Item No. **Report of the Interim Director of Planning, Regeneration & Public Realm**

Address: COWLEY HOUSE 181 COWLEY ROAD UXBRIDGE

Development: Upgrading of the existing gas supply via the installation of external gas pipe apparatus.

LBH Ref Nos: 15841/APP/2022/912

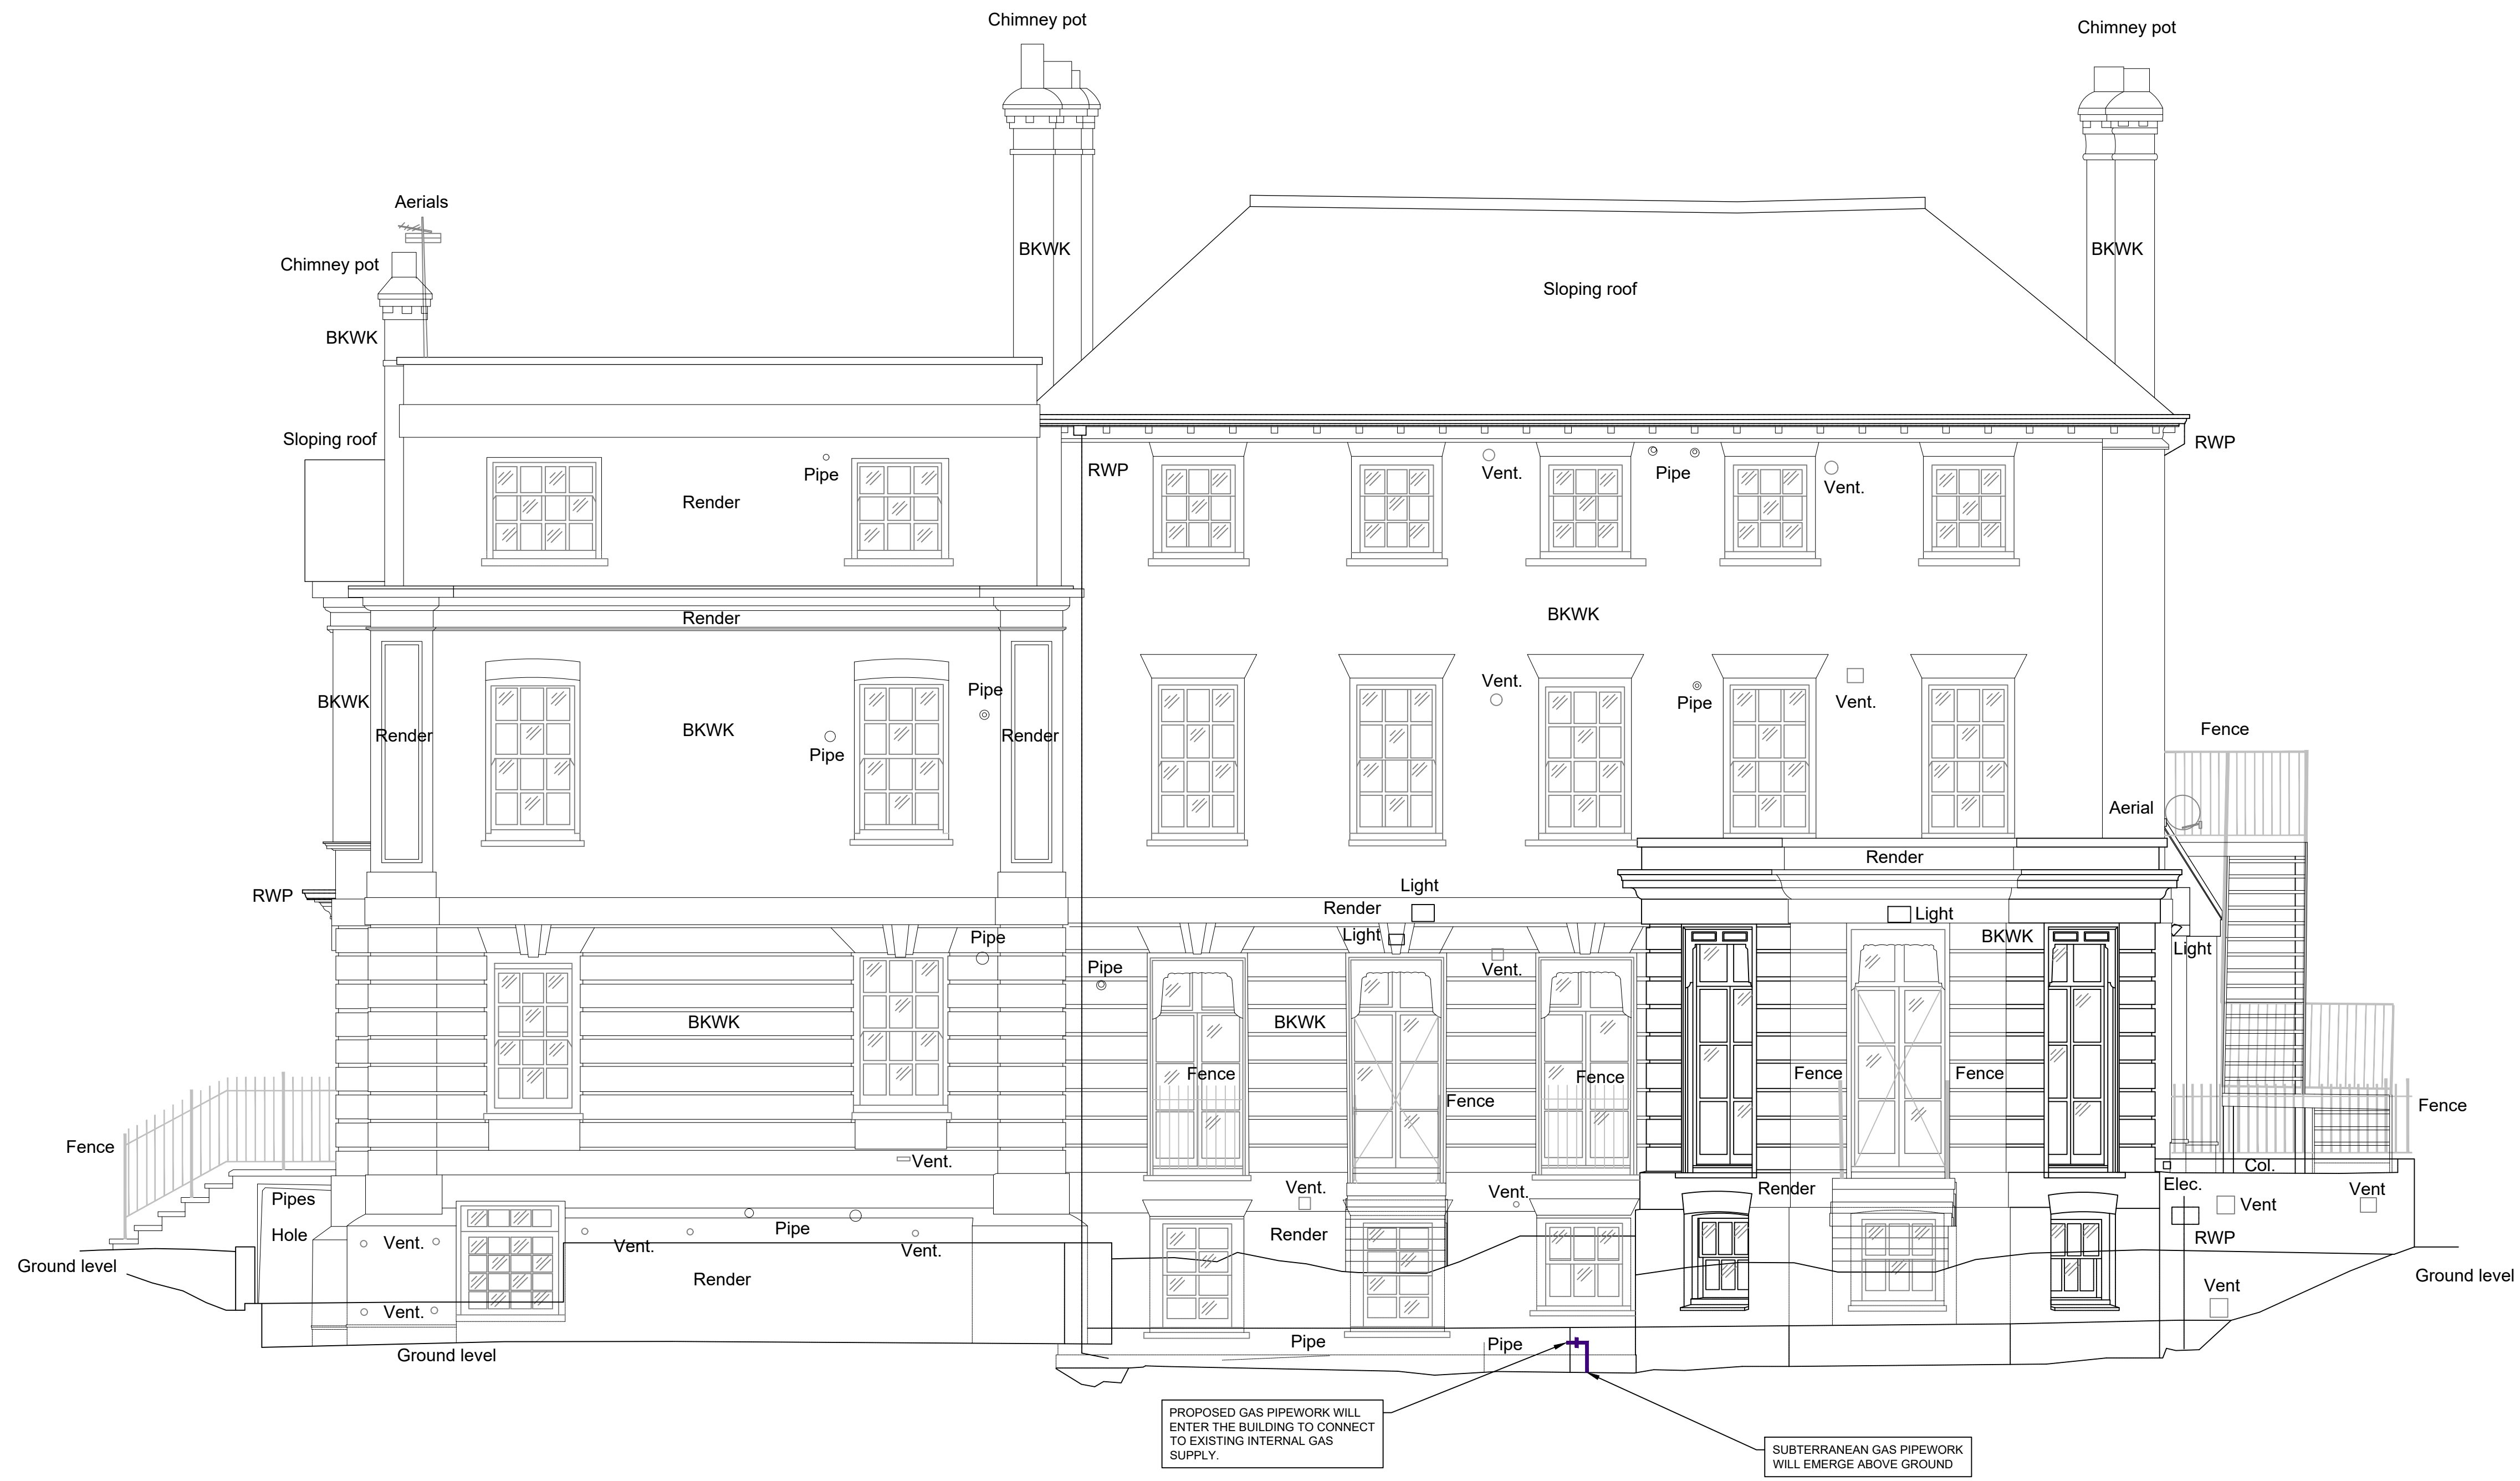
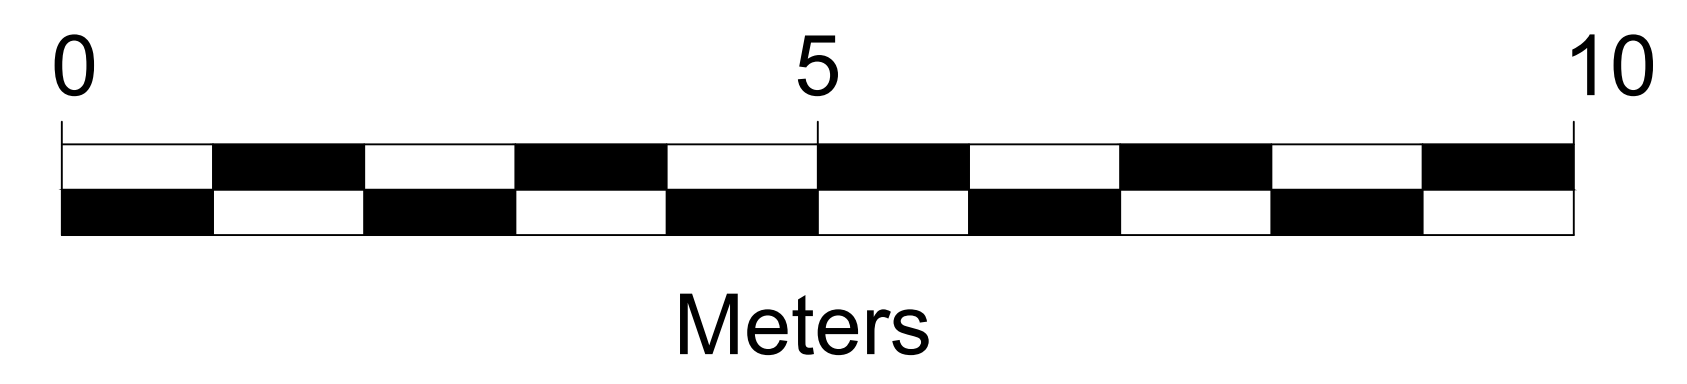
The Council's Conservation Officer has advised that the proposal would harm the character and appearance of the elevations disrupting notable architectural features, and there would likely be harm to the historic fabric with the fixings and openings. Of real concern is the relationship between the projecting cornice and pipework.

On 21st October a conservation officer conducted a site visit to discuss the proposal and see samples of pipework. It was concluded that the amended plans following the 15th May 2022 comments did not overcome the previous listed building objections and that the amended proposal would be harmful to the character and special interest of the listed building.

stretches of pipework discreetly located. It was concluded that this suggested that the long stretches of pipework externally were not necessary and were for the convenience of installation so that the flats inside did not need to be entered. The proposal remains harmful due to the cluttering of the elevations and disrupting of notable architectural features, in particular the cornice. The proposal would not respect the significance of the building and would alter its character and appearance in a detrimental way. There would also be some harm to the historic fabric with the fixings and the openings.
